DRB Application No.: 04DRB 01626(SDP) Project # 1003742
Project Name: Ladera Business Park
Agent: Shiner Construction Phone No.: 344-3461

**DEVELOPMENT REVIEW BOARD
ACTION SHEET**

Date: 25 October 2004
To: Sheran Matson, DRB Chair
From: Russell Brito, Senior Planner
RE: Project # 1003742: 04DRB-01626 (EPC Project#1001523: 01123-01405)

SHOP ELEVATIONS

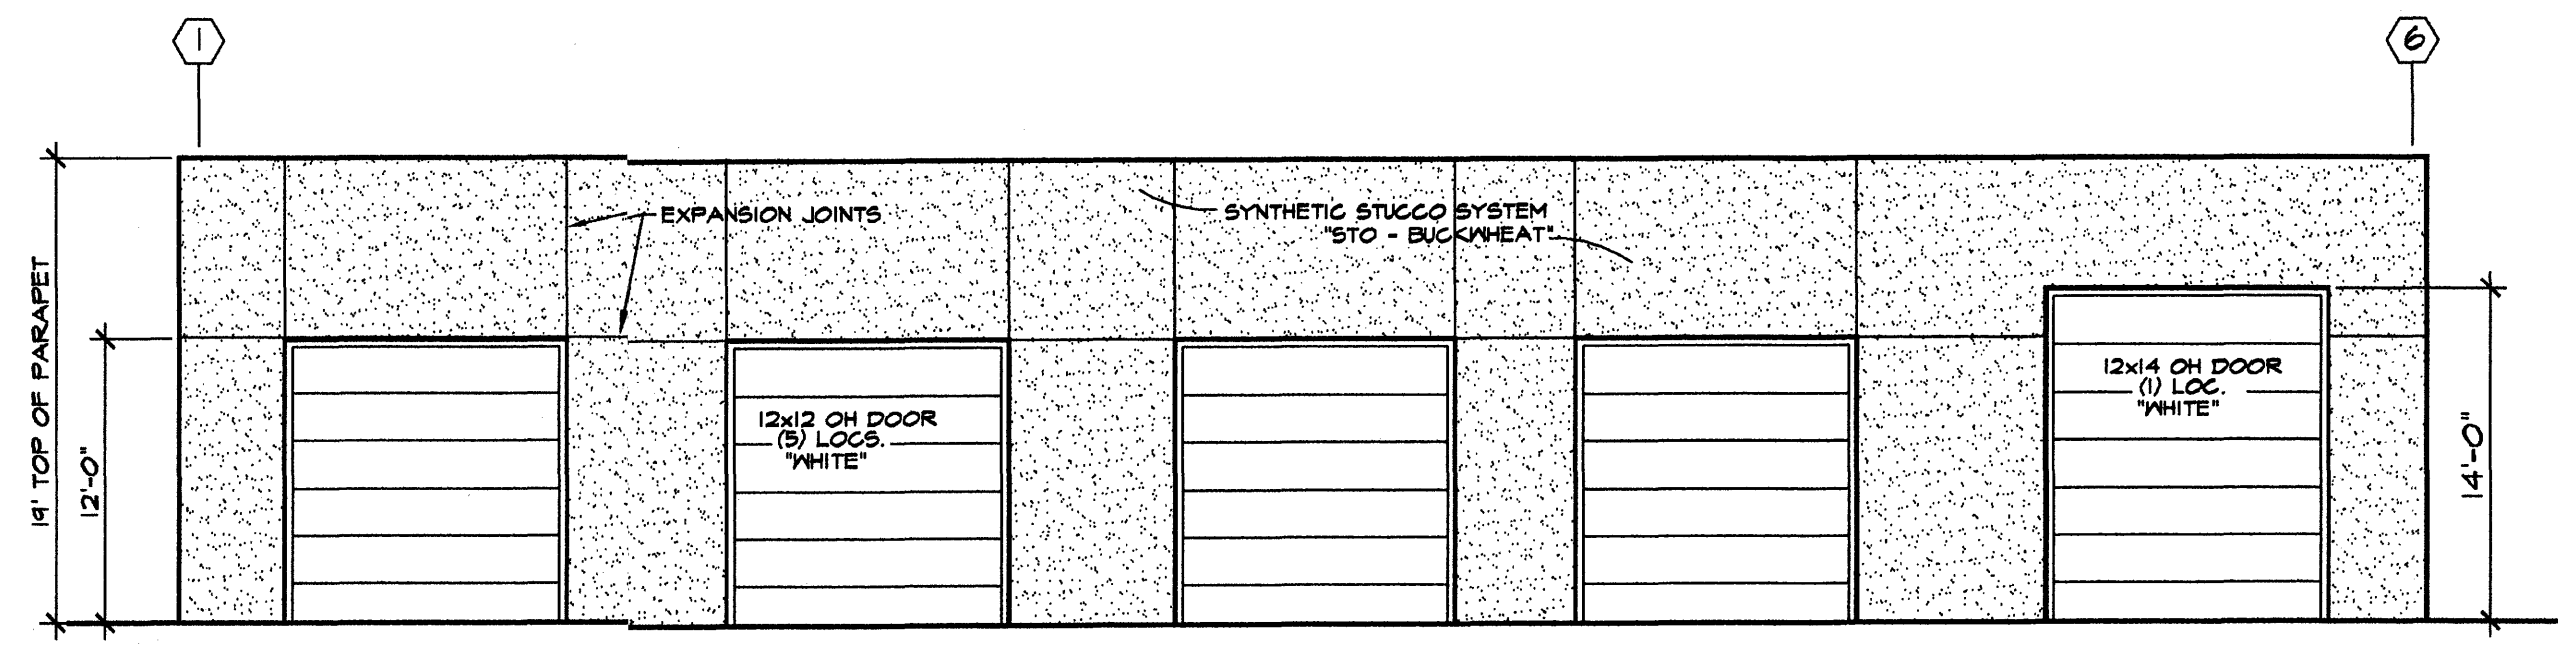
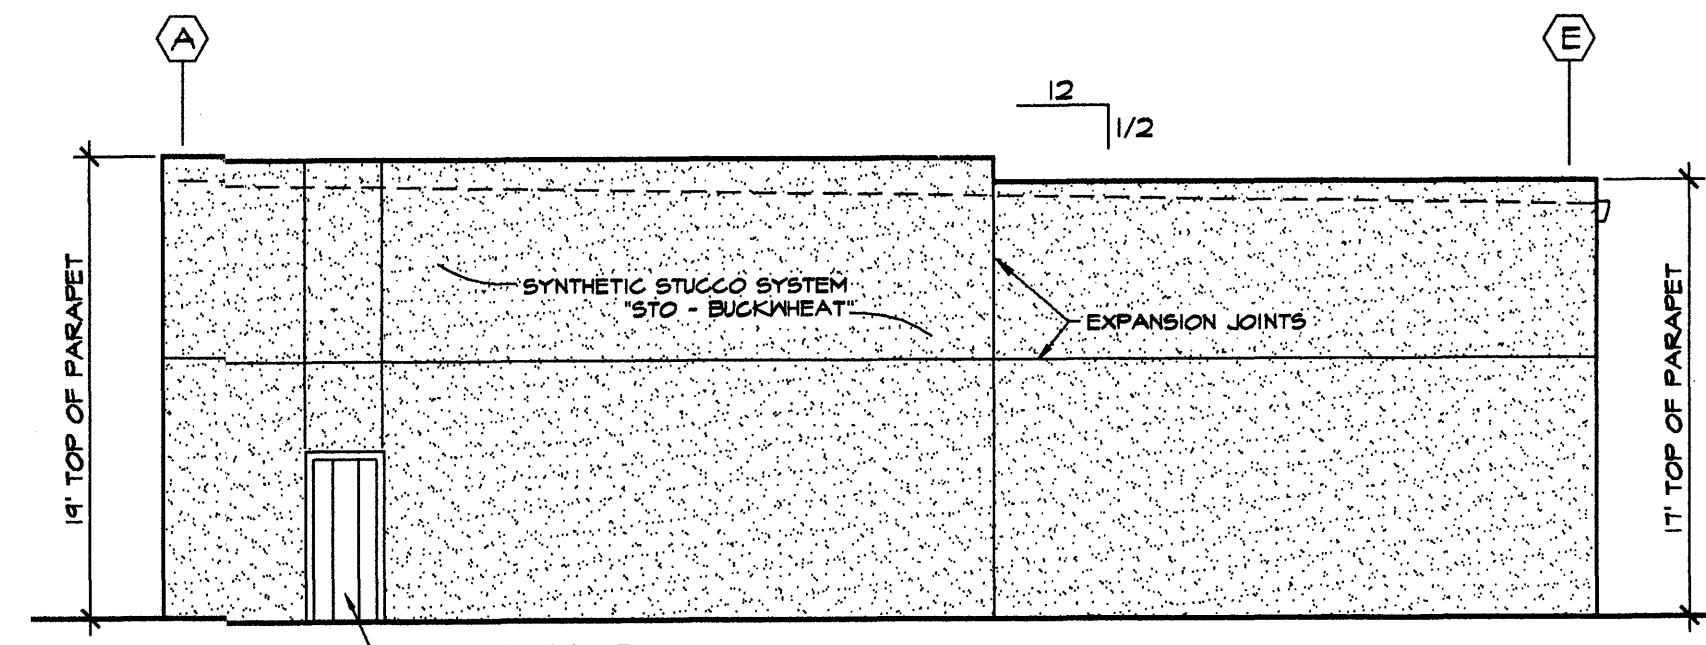
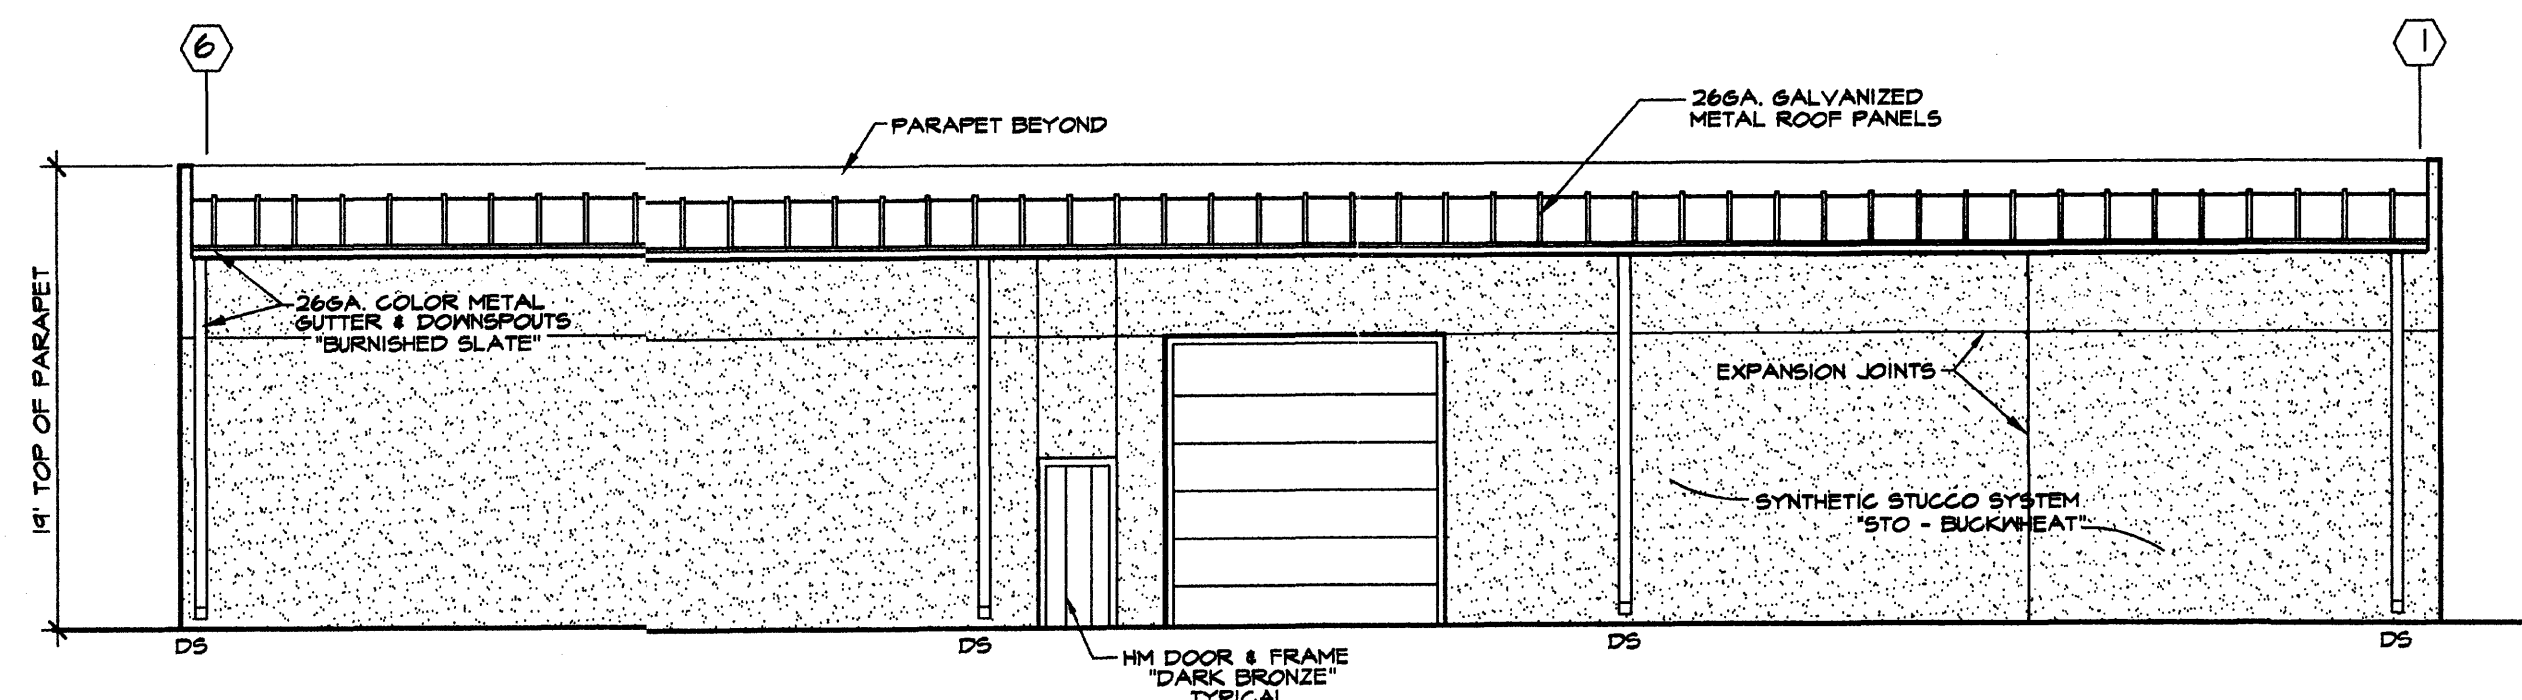
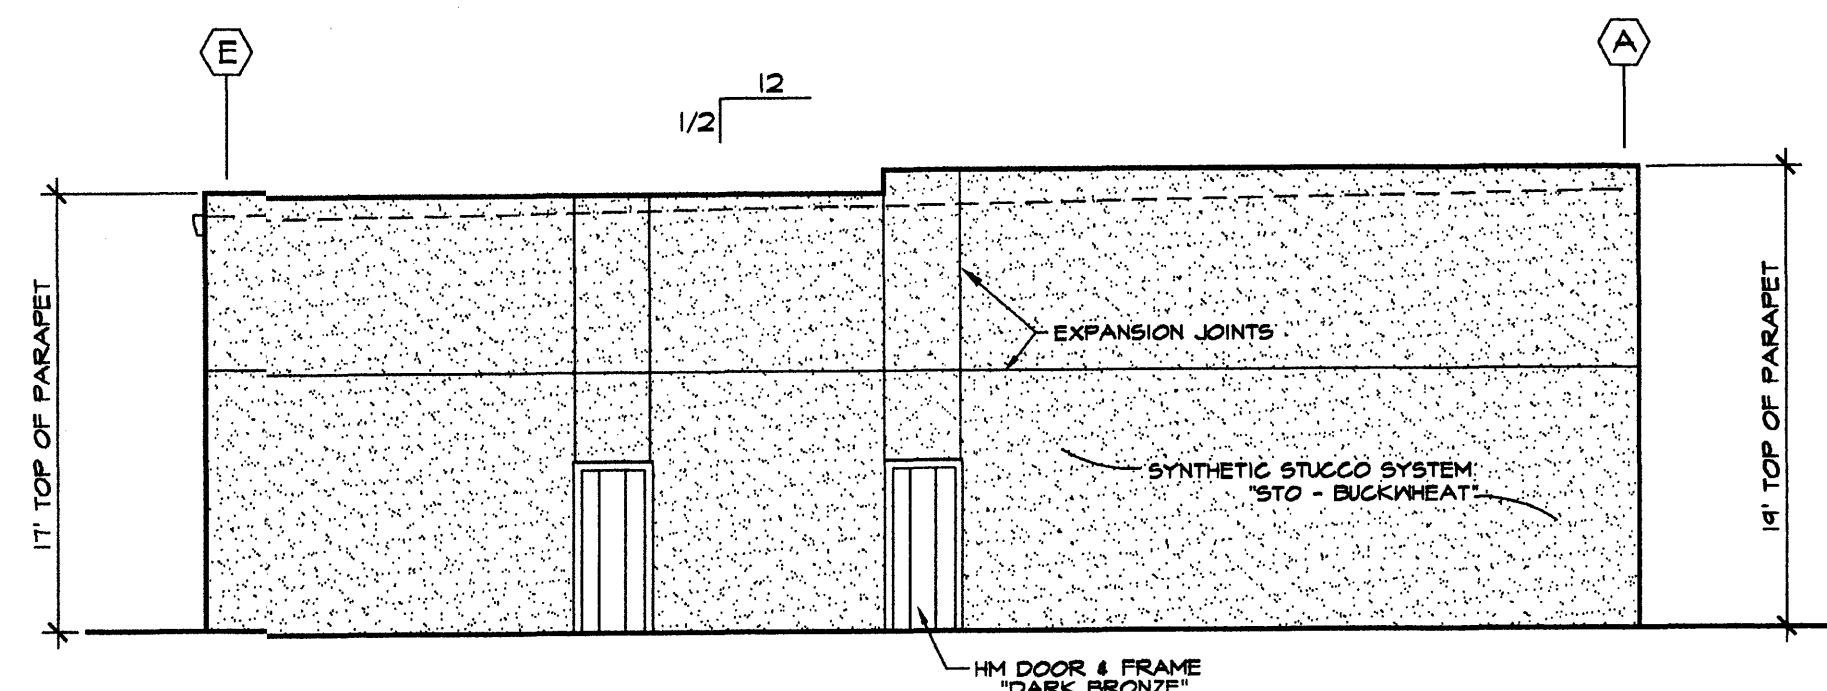
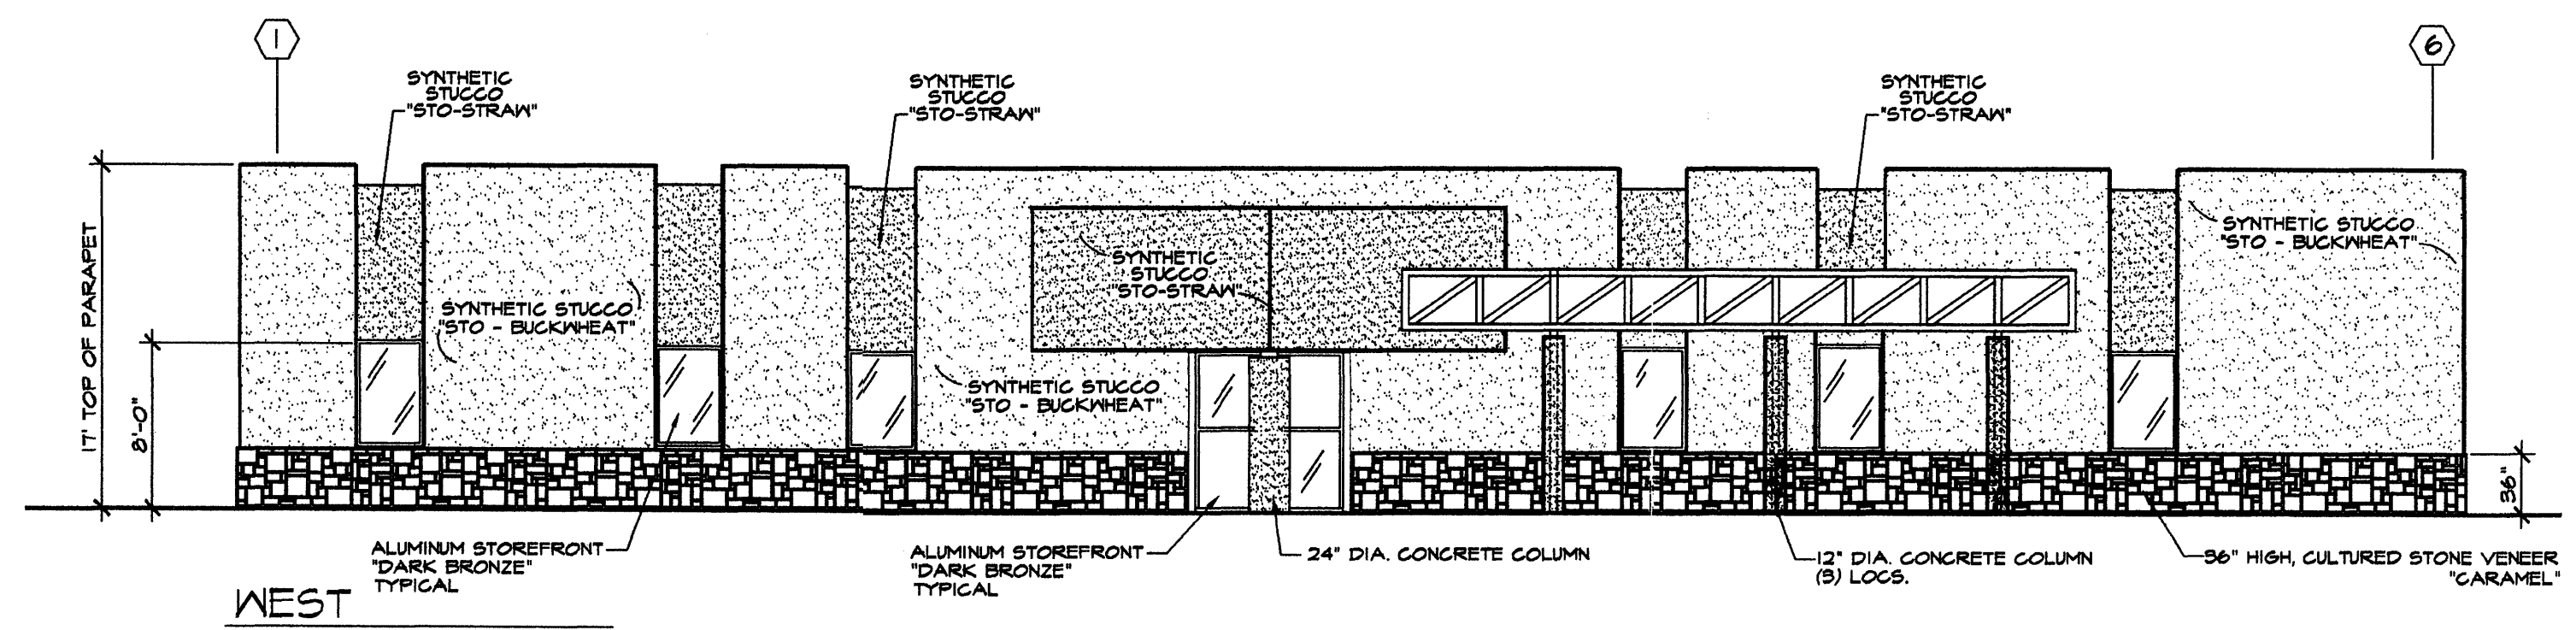
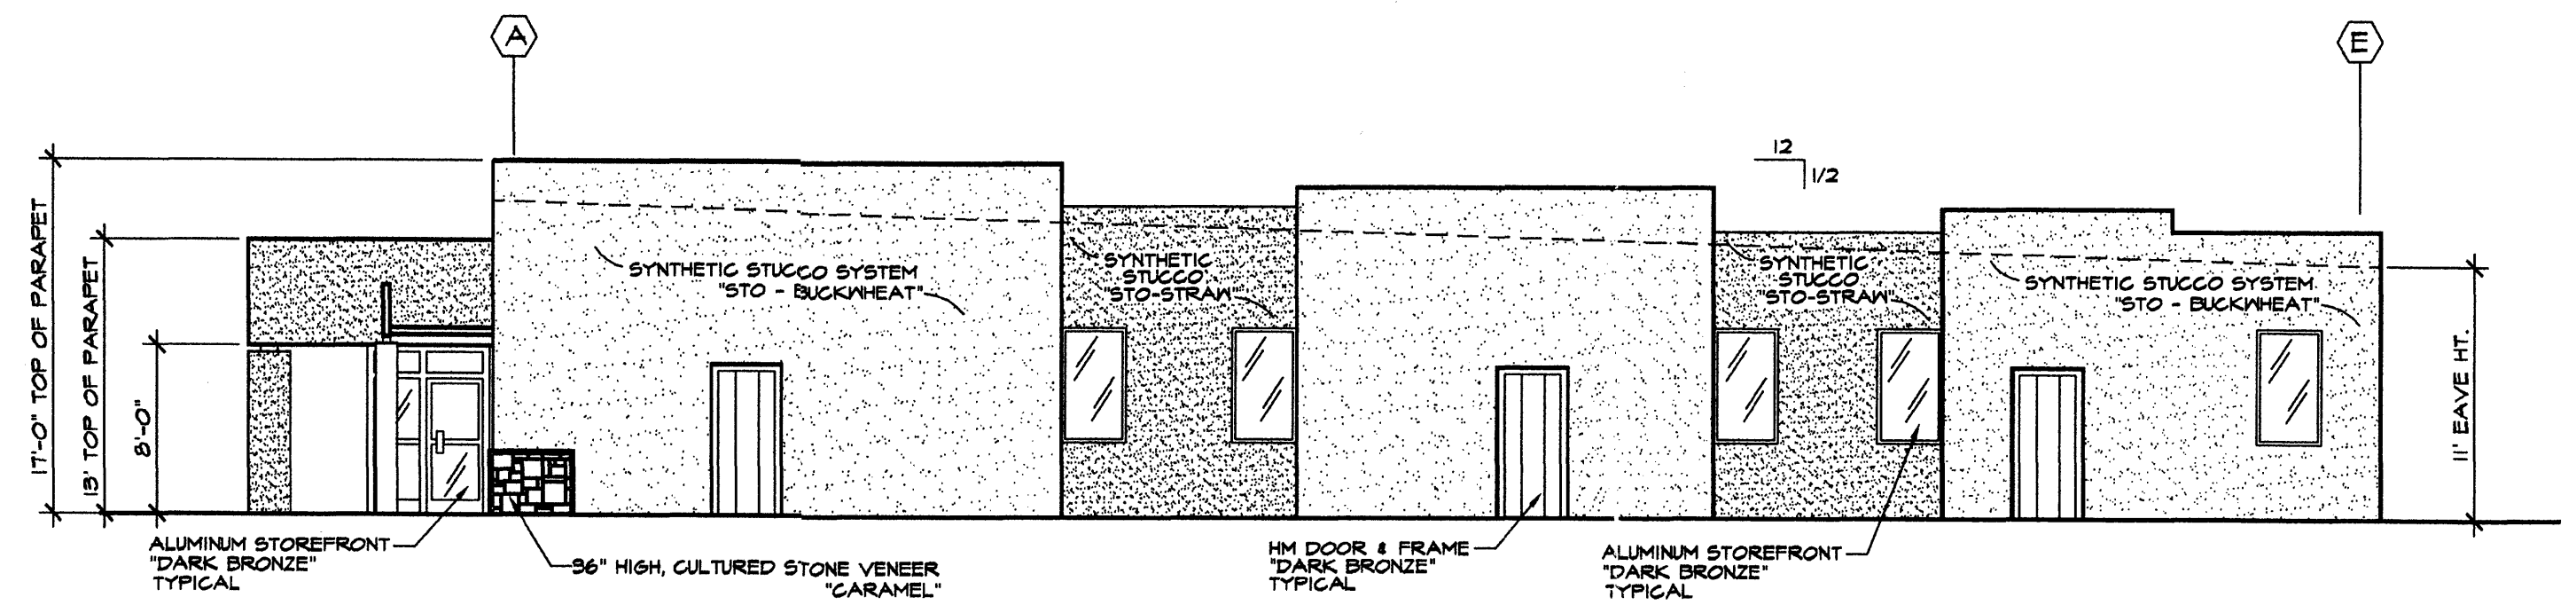
8. Show wall mounted lighting fixture locations on elevation drawings with dimensions, colors, materials and cut-off shield details.
